Rezoning Transportation Analysis
Petition Number: Insert Zoning Petition #2021-201
General Location Identifier: Tax ID 12709305

Date	Description
12-23-21	First Review (WB)

The petition is located adjacent to two City-maintained minor collectors, Weddington Avenue and Bascom Street. The petition is located in the Southwest Corridor inside Route 4.

SHEET NAME
REZONING SITE PLAN

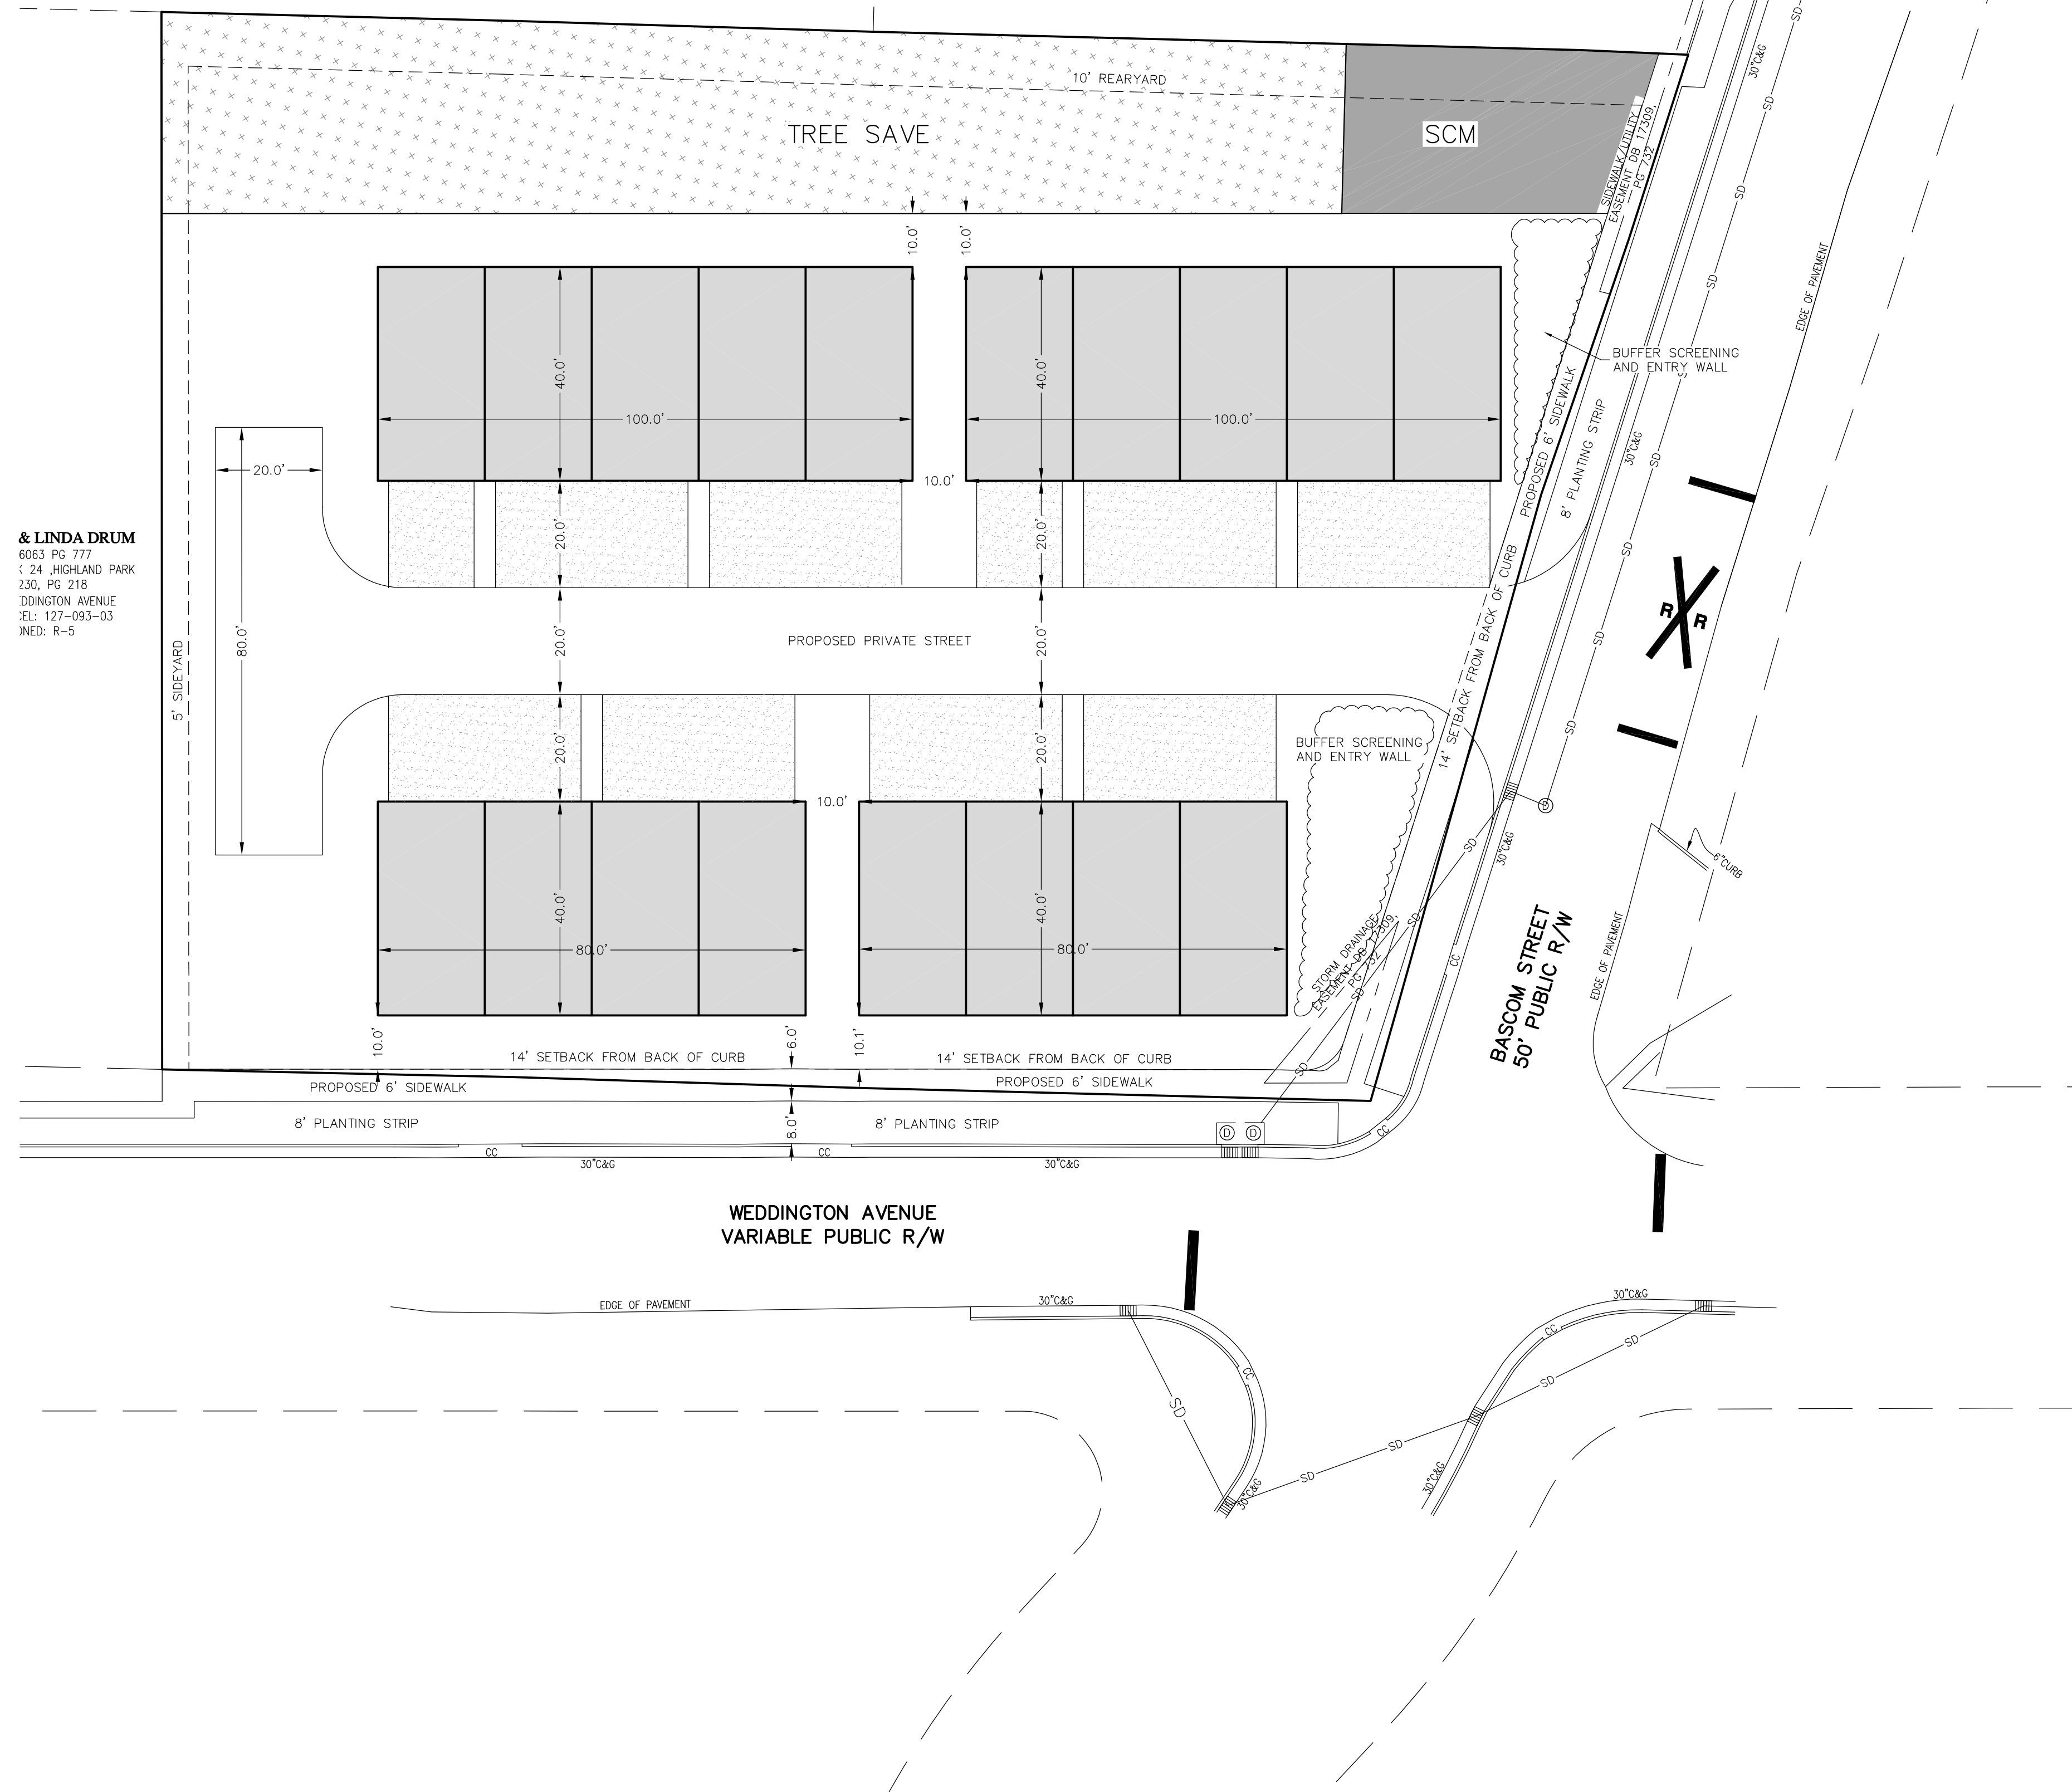
- Curbline:** The proposed zoning district has a setback measured from back of the existing or proposed future curbline.
 - Weddington Avenue:** The curb line will remain in its current location.
 - Bascom Street:** The curb line will remain in its current location.

Label and dimension the curb and gutter from the centerline for each road on the site plan.

- Revise site plan and conditional notes to commit to dedicate a 36-foot right-of-way from the road centerline. The site plan shall label and dimension the right-of-way from the road centerline.
- The proposed dwelling units exceeds 12 dwellings per acre. Per Chapter 20, Subdivision ordinance, site plan and conditional notes revisions are needed to commit to construct an 8-foot planting strip, and 8-foot sidewalk along both Collector Roads. The wider sidewalk also meets the Charlotte WALKS Policy.

- Site plan and conditional notes revisions are needed to provide 10' x 10' pedestrian sight distance easements for any portion of the pedestrian sight triangles located outside the right-of-way and within

the development. Remove proposed driveway from the pedestrian sight triangle. The pedestrian triangle measures 10 feet x 10 feet with one leg measured along the back-of-sidewalk or right-of-way (whichever is the greater distance from the curb line) and the other leg measured along the driveway face-of-curb or edge-of-pavement. Also provide Pedestrian sight triangles at the intersection of Weddington Avenue and Bascom Street.

- Site plan revisions are needed to construct a CDOT standard driveway per CLDSM 10.25E. Proposed radii must match the City standards.

7. Revise Site plan to construct two (2) accessible curb ramps at the intersection per PROWAG and ADA law.

8. Add a site plan note specifying dedication and fee simple conveyance of all rights-of-way to the City before the site's first building certificate of occupancy is issued. CDOT requests rights-of-way set at 2-feet behind back of sidewalk where feasible.
9. Add a site plan note specifying that all transportation improvements will be approved and constructed before the site's first building certificate of occupancy is issued. The petitioner may phase transportation improvements if said improvements and phasing are explicitly described in site plan notes.
